To, Maya Cullen  
Ribble Valley Planning  
Council Offices  
Church Walk,  
Clitheroe

**Re: Planning Application No. 3/2025/0929**  
**Proposal: Change of use of the existing dwellinghouse (C3) to a small children's residential home (C2)**  
**Location: 17 Redwood Drive Longridge PR3 3HA**

I wish to formally object to planning application **3/2025/0929** on the following material planning grounds.

Garage Floor Plan
1:50 Scale

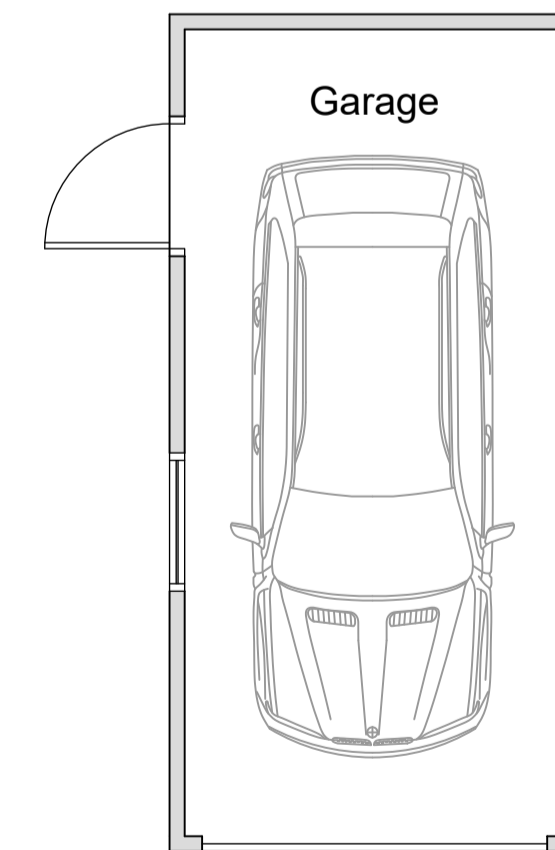
The plan indicates provision for four parking spaces, including one within the existing garage. Given the narrow dimensions of the garage, it is unrealistic to assume regular use by staff, particularly during shift changeovers, increasing the likelihood of on-street parking.

Proposed Site Plan
1:50 Scale

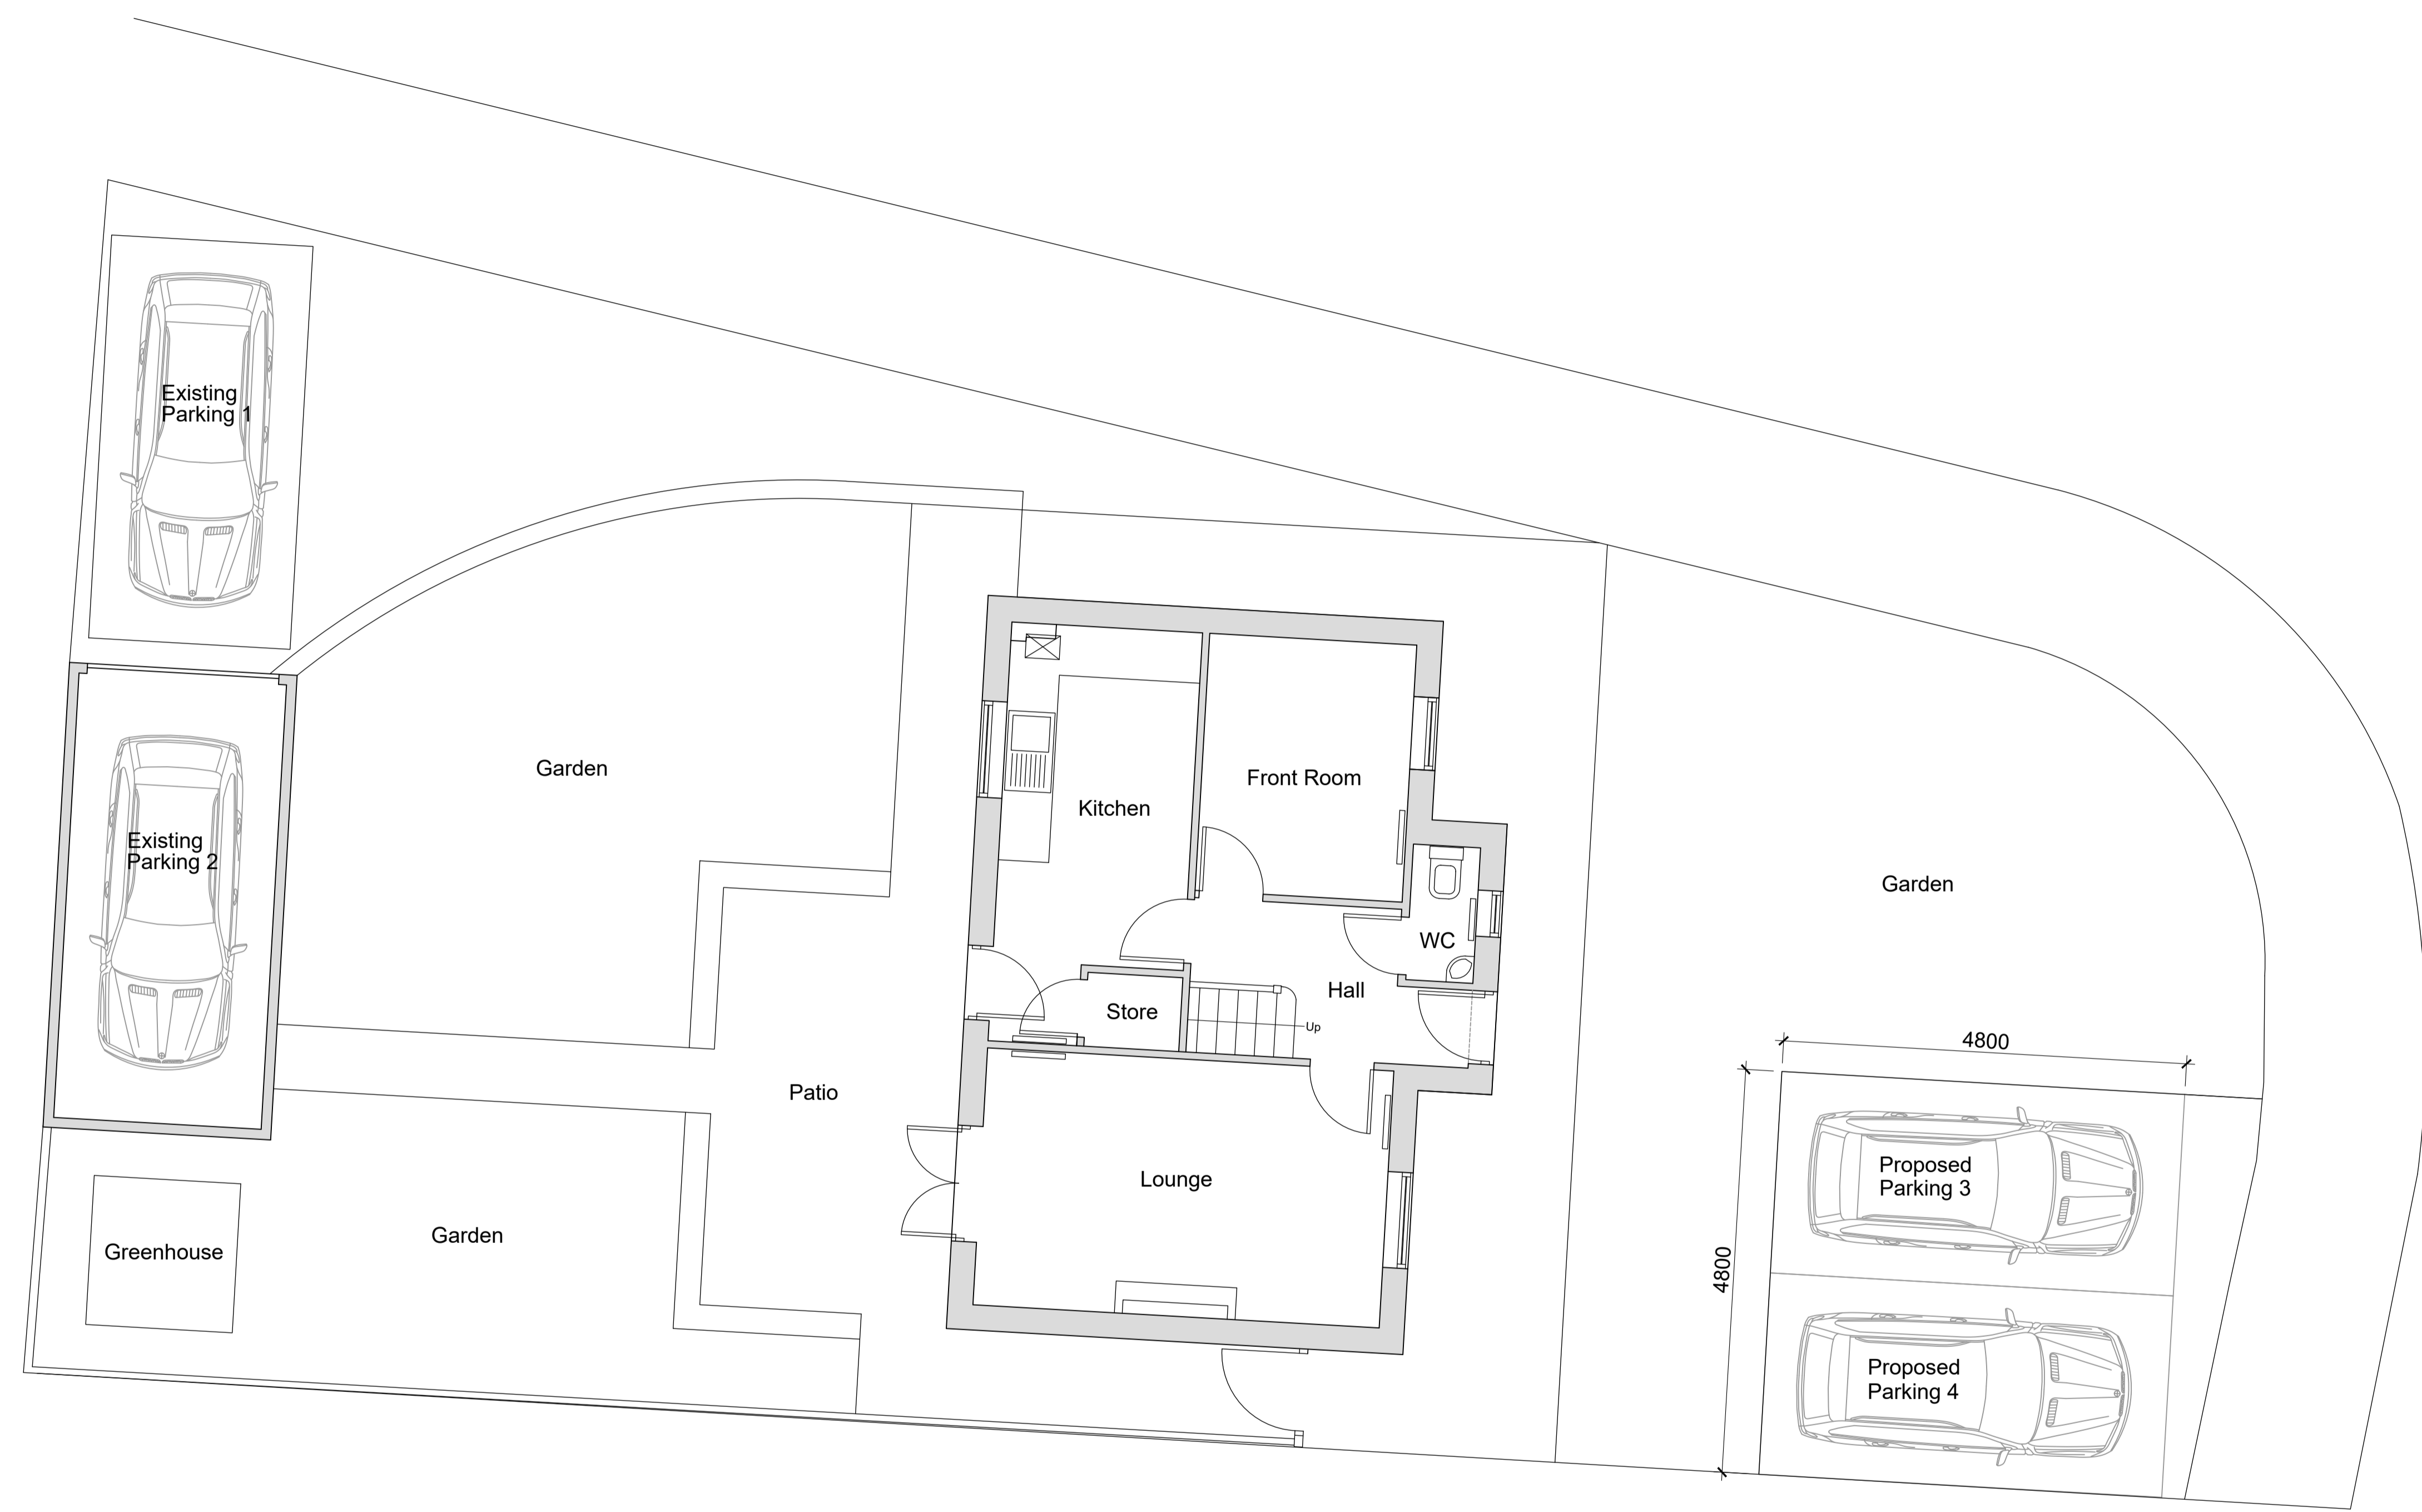
The application states that the proposal requires no new driveways, infrastructure, or external alterations. This is **contradicted by the submitted site plan**, which shows the installation of an additional driveway to the front of the property accommodating two vehicles.

On-street parking in the locality is already constrained and poorly managed. Any deviation from the operational assumptions set out in the application would exacerbate existing highway and parking issues. The discrepancy between the written statement and submitted

plans raises concern regarding the accuracy and transparency of the proposal and its longer-term intentions.

The parking shown on the application is misleading. There is only road parking outside the house (as opposed to parking places on the grounds of the property). As regards the other two parking places, one of them is a garage, and I can't see two cars ever being placed there, as one car is likely to have to move to allow the other one out. As a consequence, I feel that parking problems will likely arise, thereby turning a quiet residential area into something else.
